Subject: 2025/93201 at location Land off, Wood Bottom Road, Netherton, Huddersfield, HD4 7DJ

Please see ecological commentary below:

Figure 2
Post-development Habitats Map

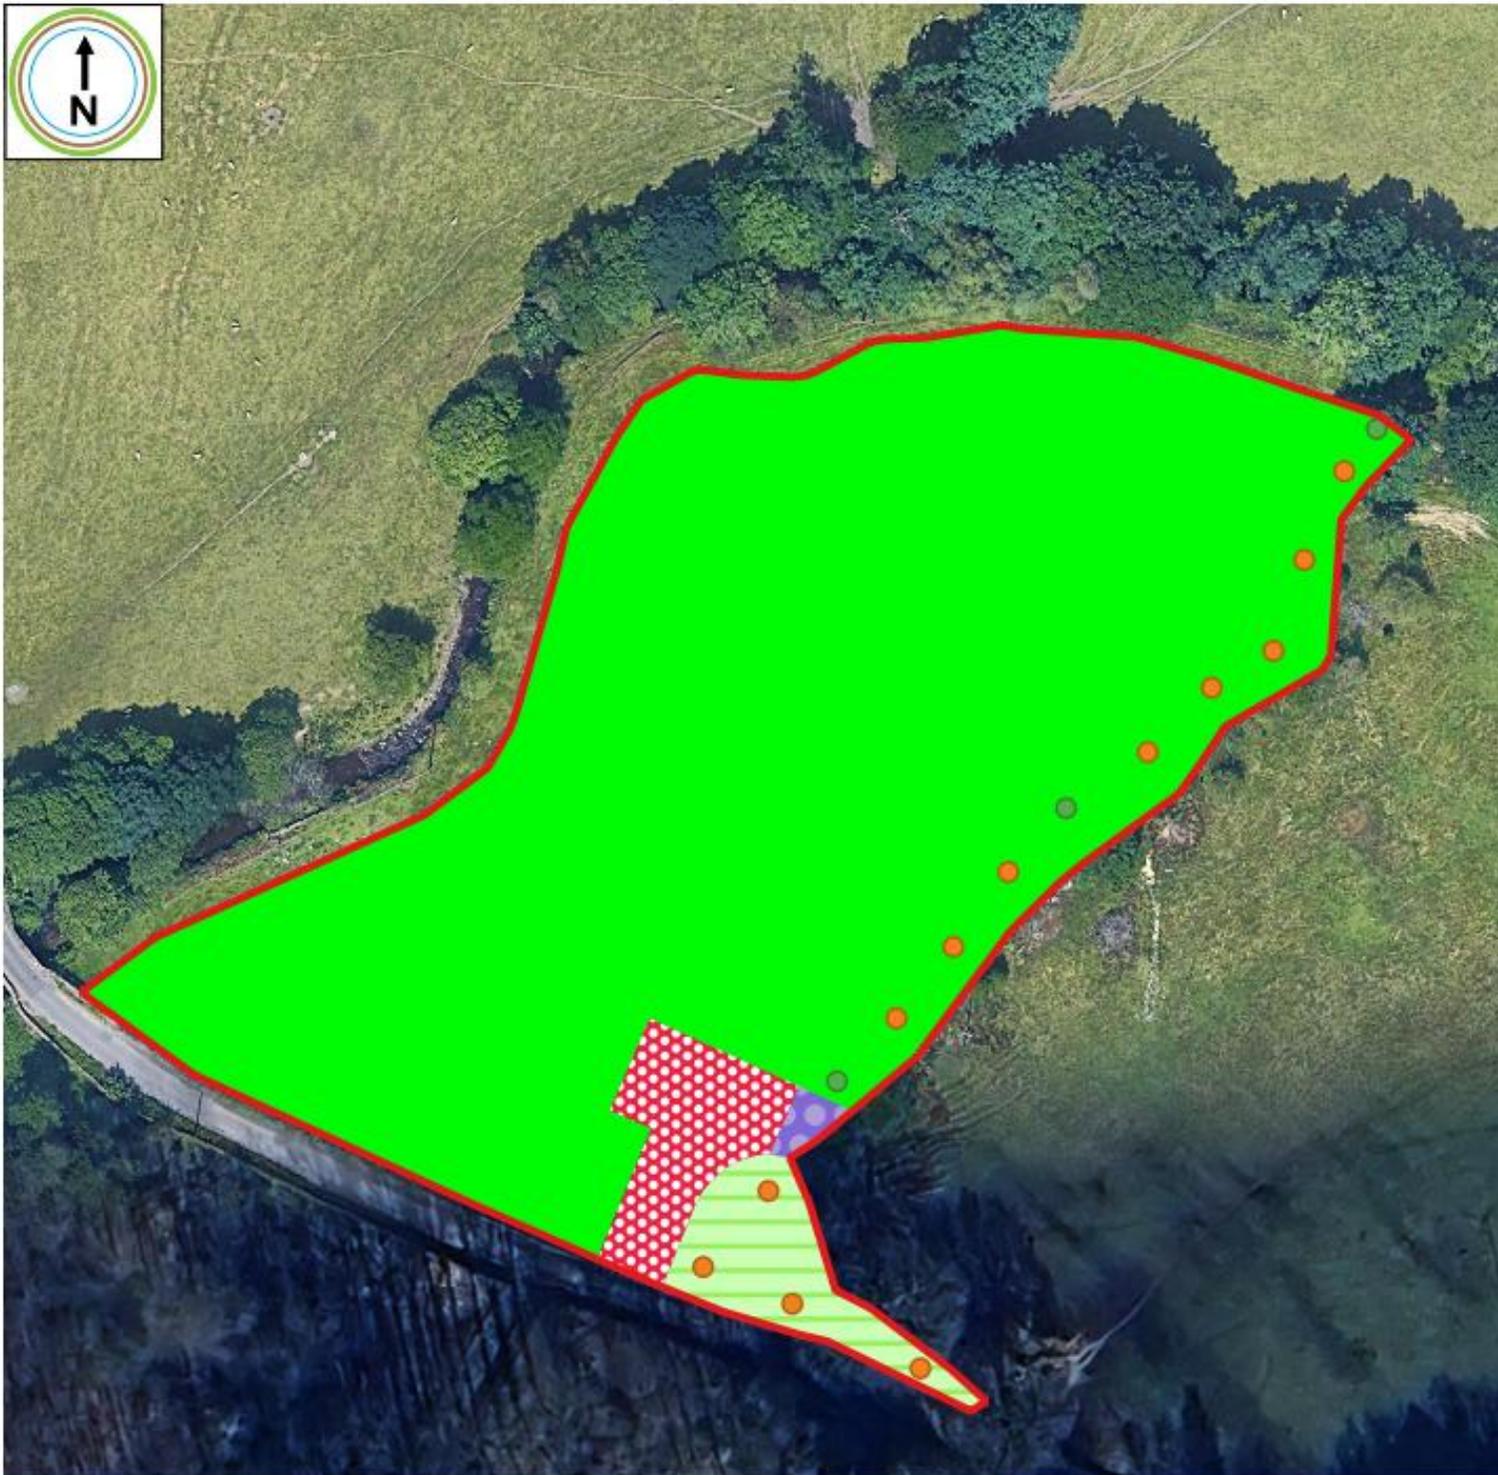
The report indicates an onsite net gain of 0.26 (10.45%) habitat units. This will be through the creation habitats and hedgerow with low to medium distinctiveness.

We consider that the onsite element of the BNG proposal will not result in significant onsite gain as it would be delivered by. This does therefore not need to be secured for 30 years but could be secured by a simple landscaping condition, if appropriate, to ensure it is provided and maintained for an aftercare period.
